# CITY OF ALBUQUERQUE

Hydrology Section Planning Department  
David S. Campbell, Director

June 7, 2019

**RE: BEK Distribution Facility – 601 Gallatin Pl. NW  
G&D Plan and Drainage Report Engineers Stamp Date: 5/16/2019,  
Hydrology File: FJ10D002G1**

OVERALL
GRADING PLAN

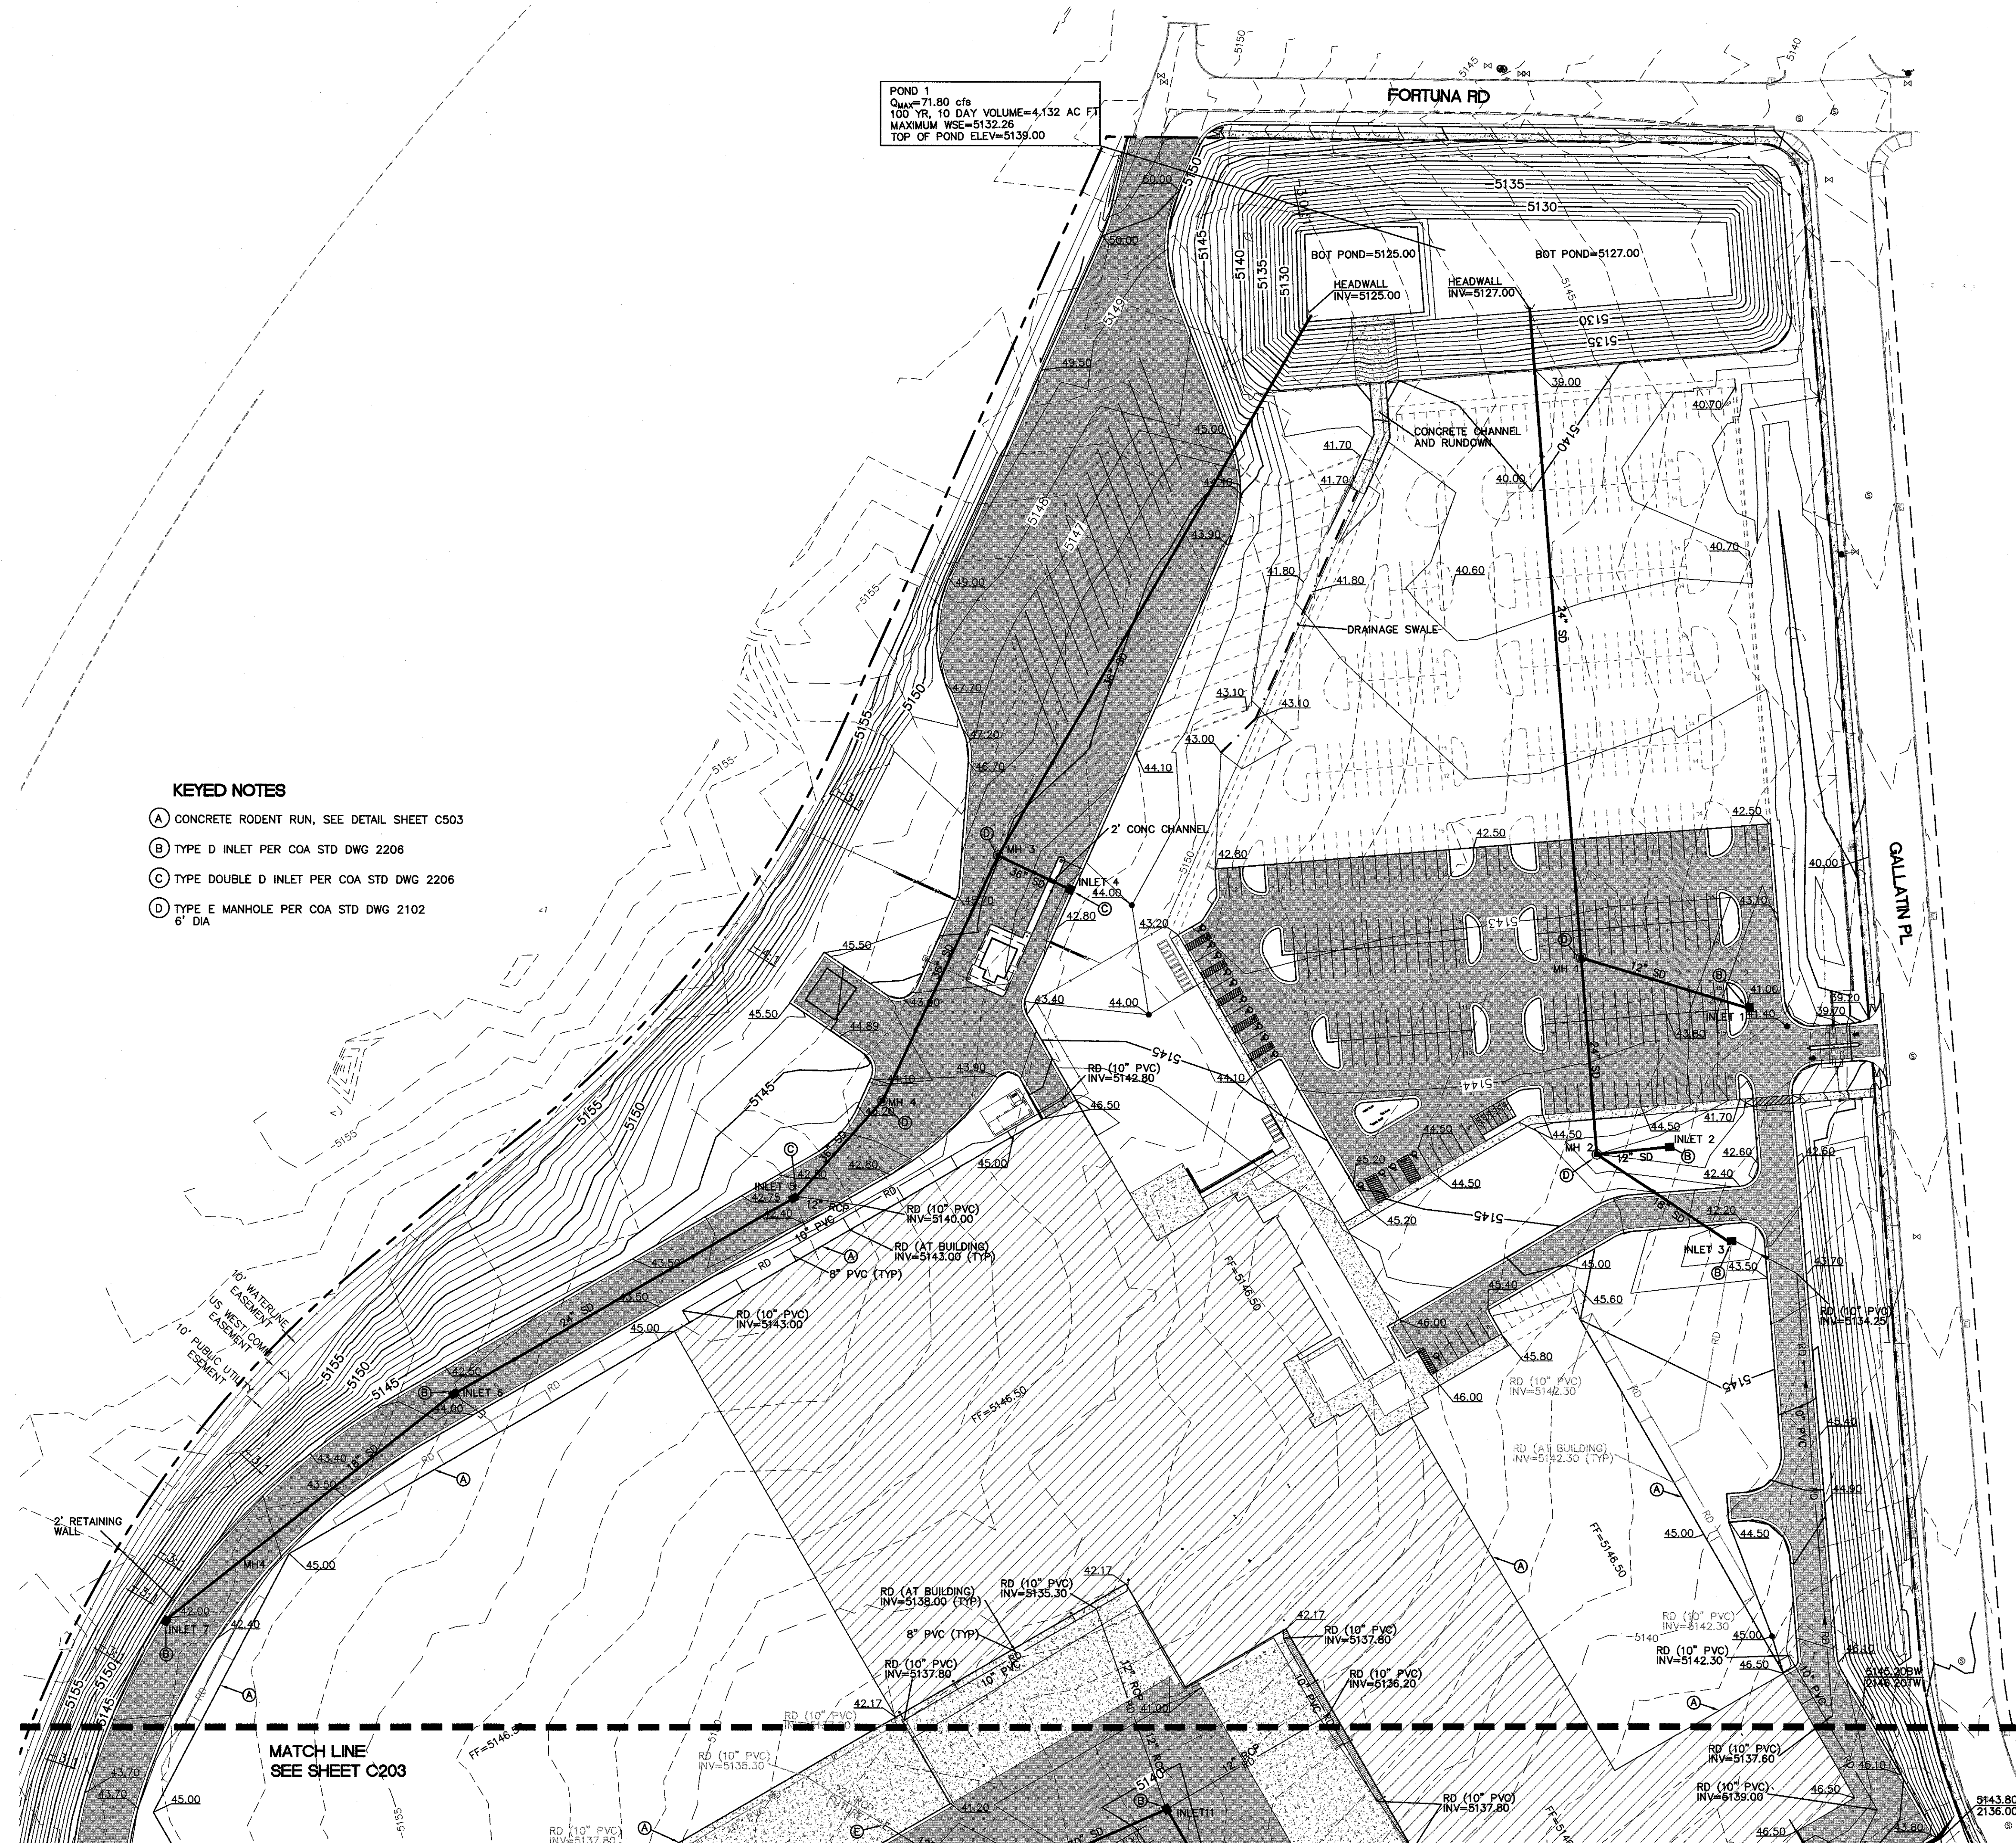
1. The contours on the steep slopes along the west side indicate a 2.6:1 slope. Please either change the slope label from 3:1 to 2.6:1 or change the contours.

2. Please add a note near the west slope that states "All disturbed areas must be stabilized prior to Engineer's Certification for Certificate of Occupancy".

6. How will drainage get out of the sump in the C&G on the east side of the Staging area?

7. Surface drainage in the future staging area and the future parking lot next to the pond appears to enter the pond in two places but only one has a rundown. Lined conveyance systems should be added to the plan to convey drainage from the paving proposed with this building permit through the future paving area and into the pond. Please revise the G&D Plan adding lined swales and typical sections through the future north parking area and into the north pond.

8. Please label the contours in the north east corner of the parking lot and verify that the spot elevations agree with the contours. If they are not 5141 and 5142 then please revise the grading to decisively contain the parking lot drainage and convey it into the north pond.

9. The contours indicate excessively steep slopes west of the staging/parking lot about 350' south of the northwest corner of the site. The contours indicate erratic slopes varying from 1% to 10% with abrupt grade changes in the northwesterly 250' of the staging/parking lot. Please revise the grading.

10. The Contours between 5140 and 5150 indicate a slope of about 2:1 on top of the sidewalk in the public right of way at the west end of Fortuna. Please revise the grading and add a typical section to the G&D Plan showing the sidewalk, ROW line and slope. If a retaining wall is added, show the footer with dimensions from the footer to the ROW line. Also show the fence on the G&D Plan and in the section with dimensions.

12. Please add the fence to the legend. Please also identify the bold line style - line, dot, line, dot - shown in the buffer between the street and parking lot in the north east corner of the site.

13. Please show the PNM easement adjacent to and on this tract in the west corner. Either revise the plan to eliminate the grading within the easement or provide written permission from PNM for grading inside of their easement.

14. The finished contours are missing between the east side of the parking lot and the street in Gallatin Place and Los Volcanes Road. Please show proposed contours all of the way to the existing street to indicate the proposed grade of the sidewalk in the public right of way and the landscape area on the private side of the sidewalk. Also please add a few typical sections showing the existing C&G the new sidewalk, the ROW line, the fence, and the slope and/or retaining wall with dimensions both horizontal and vertical. Please include the area between the parking lot and the Right of way in the sections. The area appears to be wide enough to add retention ponds which may be required to limit the discharge to the allowable rates.

STORM SEWER PLAN AND PROFILE

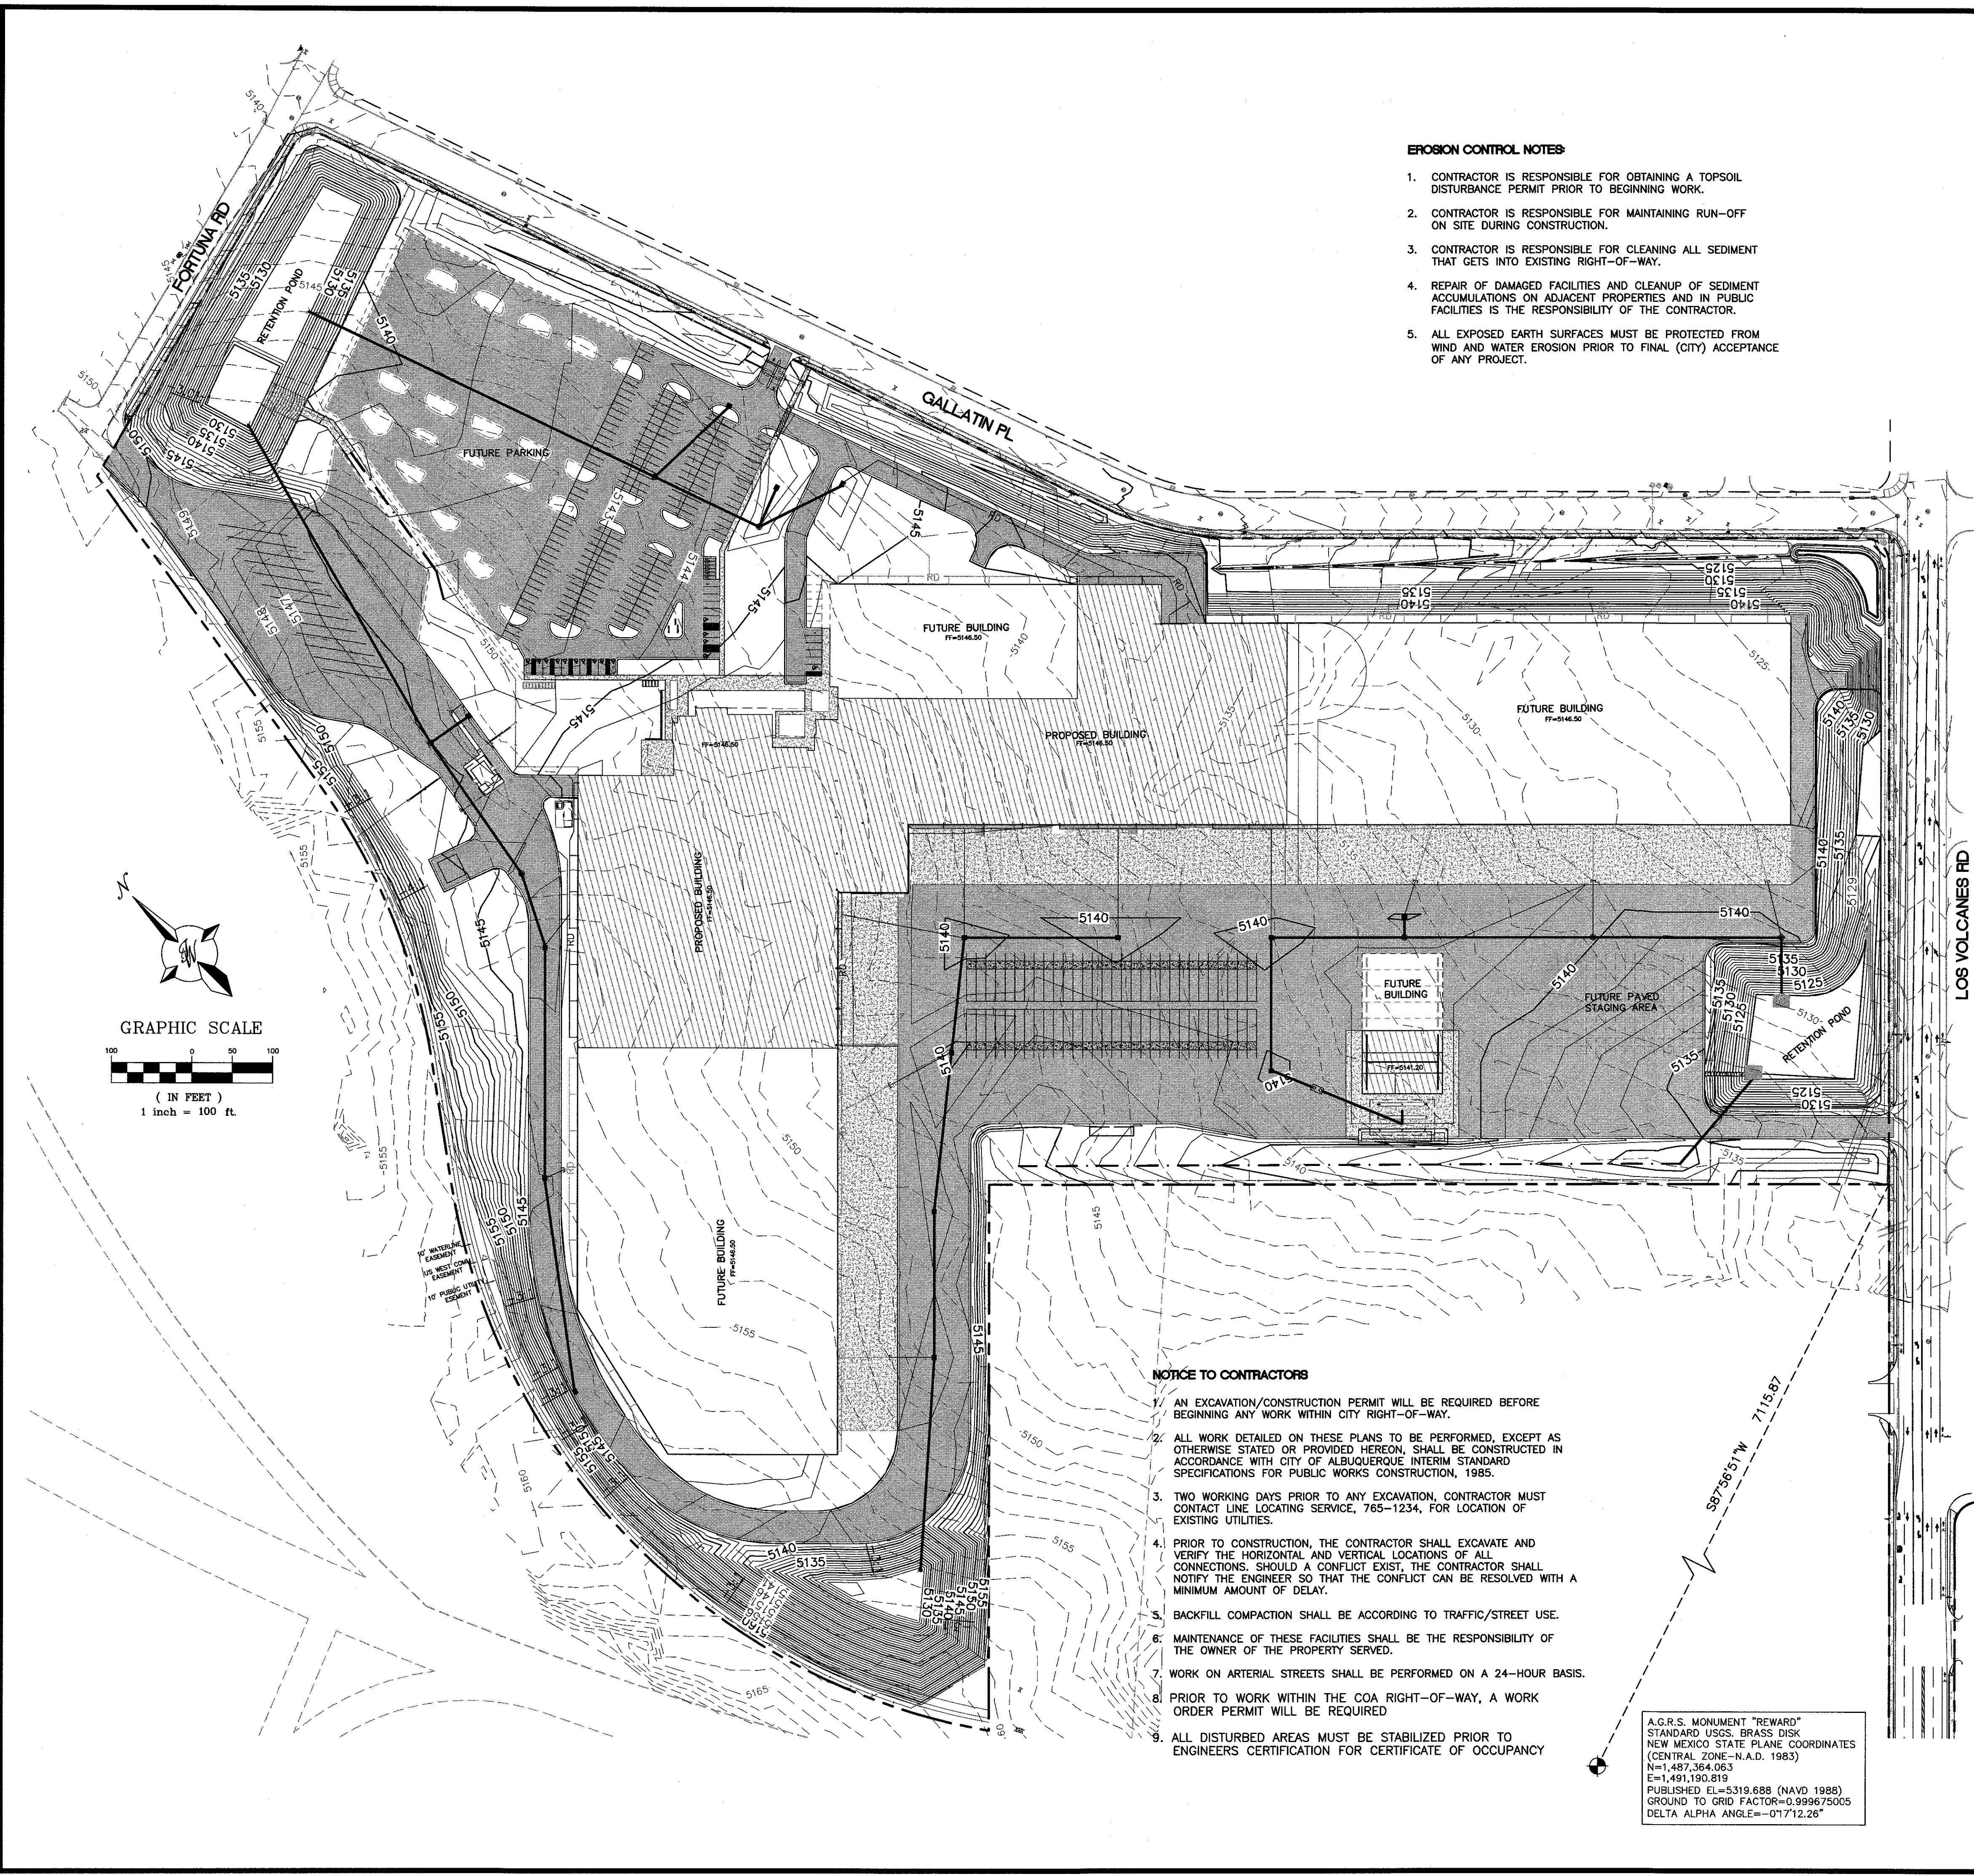
15. HGL calculations are required for the storm drain in the north east corner of the site where failure of the storm drain could result in excessive stormwater runoff to public streets. Also please add a profile and HGL calculations for the storm drain on the south and east side of the building.
